Application No: FP/84/21/PL
Site Address: Land adjacent to The Gun Post Clyde Road Felpham PO22 7AH
Description of works: 1 No. additional self-contained beach hut with sleeping accommodation. This site is in CIL Zone 4 (Zero Rated) as other development.

Thank you for your internet representation made on 10th May 2021 which has been recorded as an objection with the comments as follows:

Street Scene

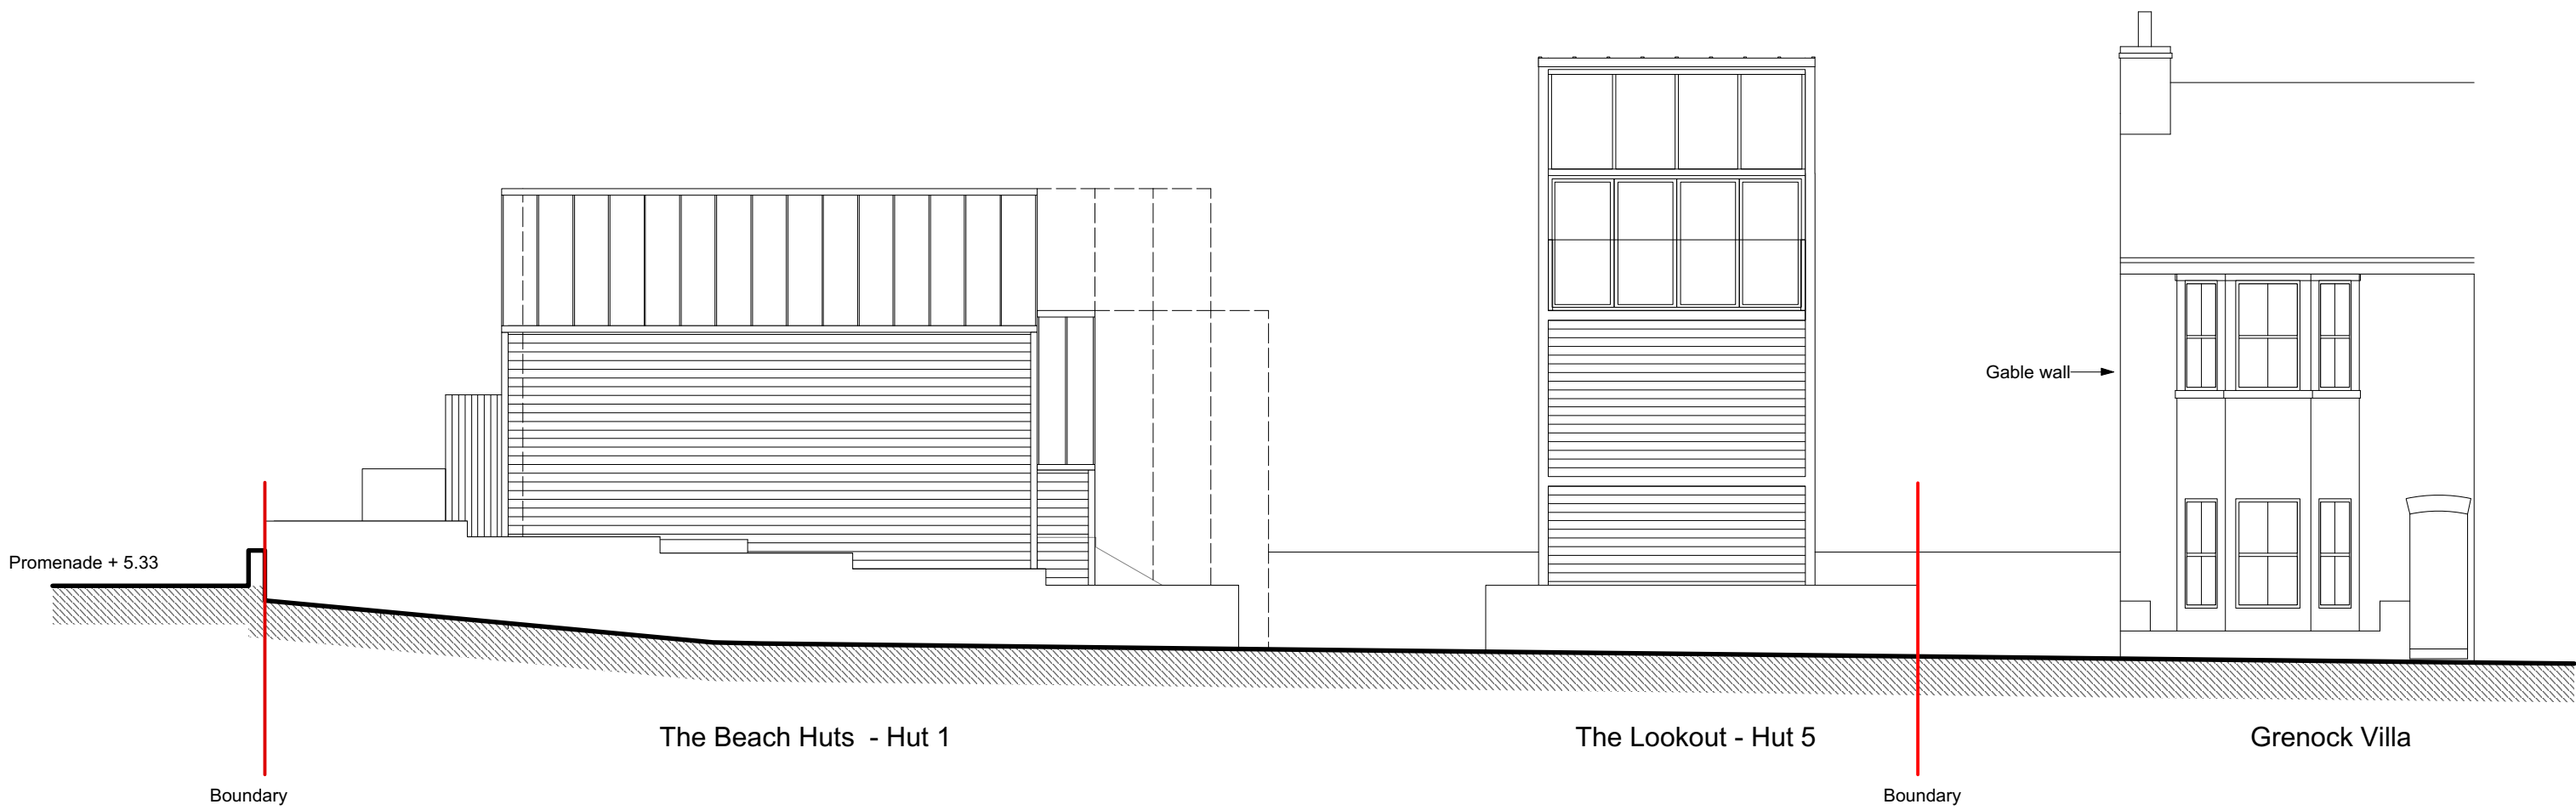
Too high for surrounding area, and overcrowds an already small site. Results in restricted and difficult parking, and yet more traffic to the Hotel, especially now Blakes Terrace outside eating area has been created.

Elevations

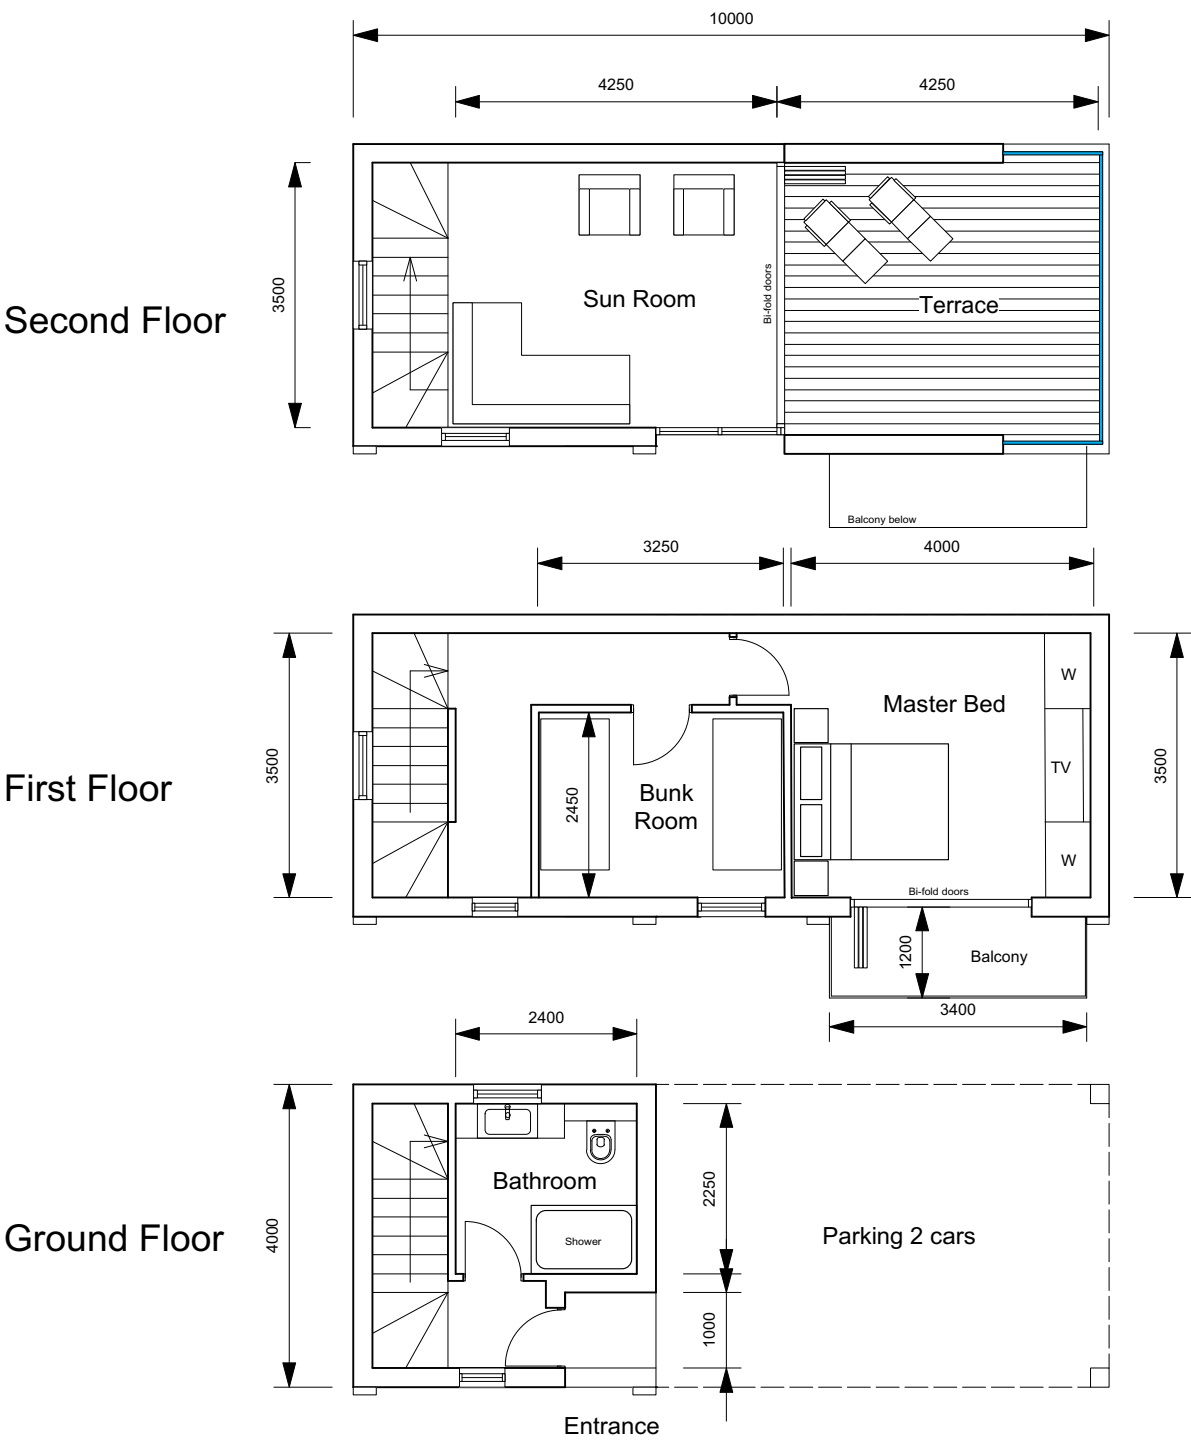
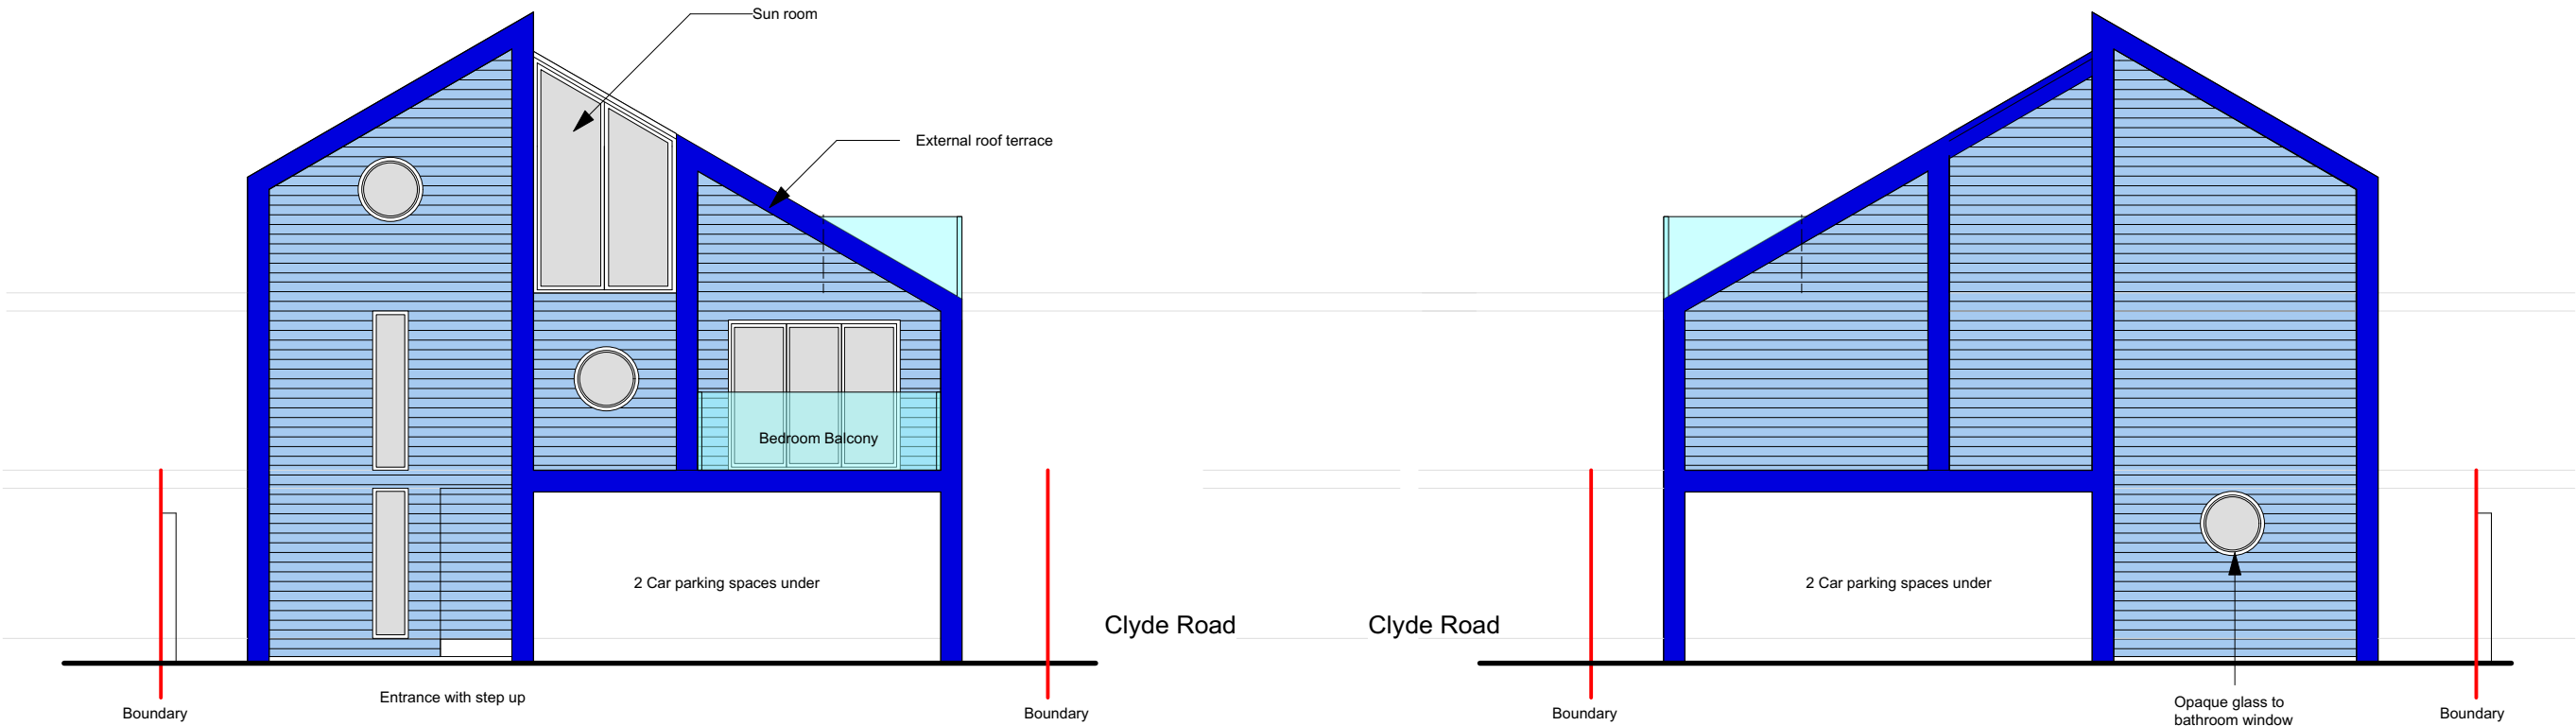
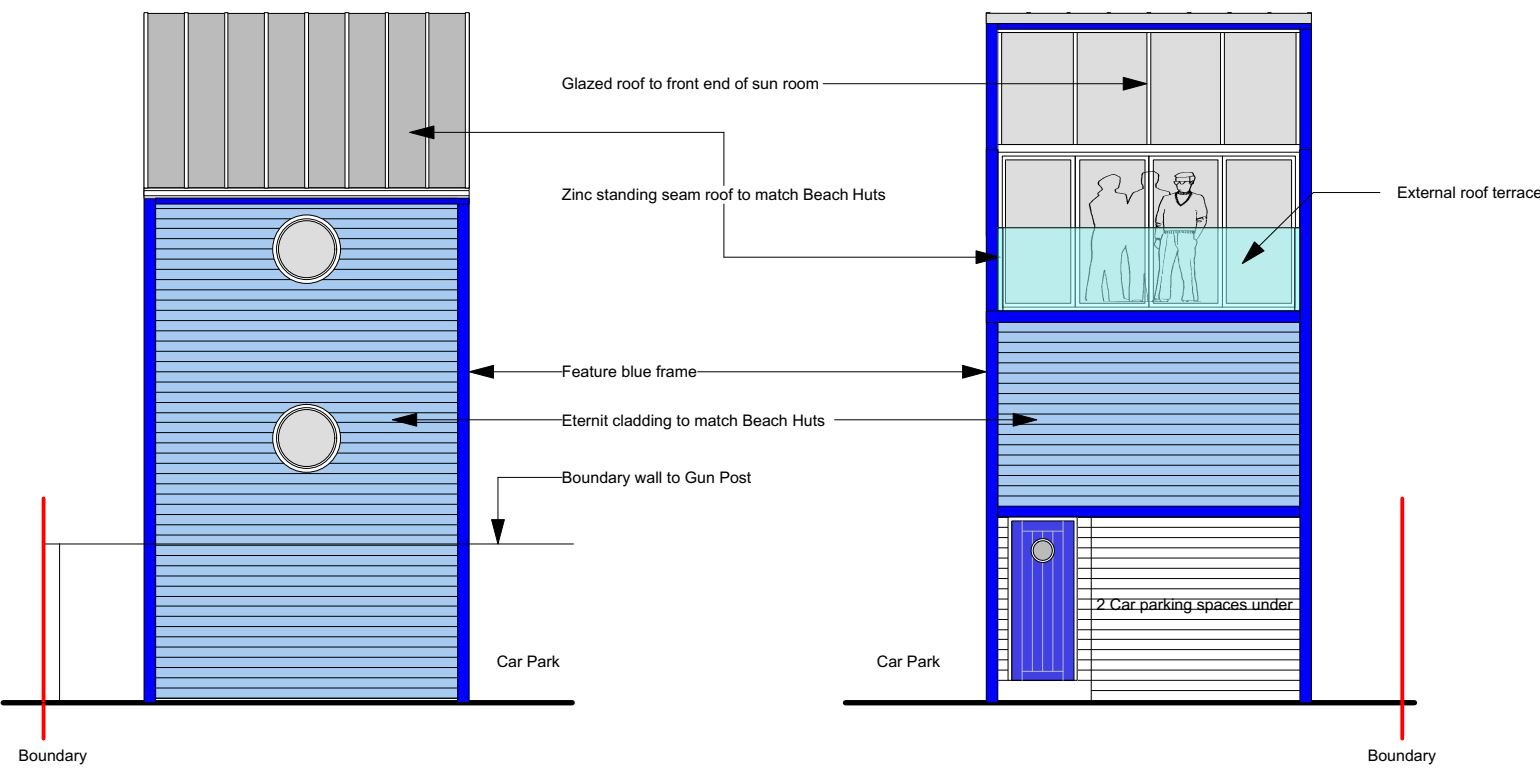
NB: The proposed balcony, and particularly roof terrace, will overlook the rear of our property, garden and bedroom windows.

What kind of foundations will be required for 3 storeys? This site sits on shingle.
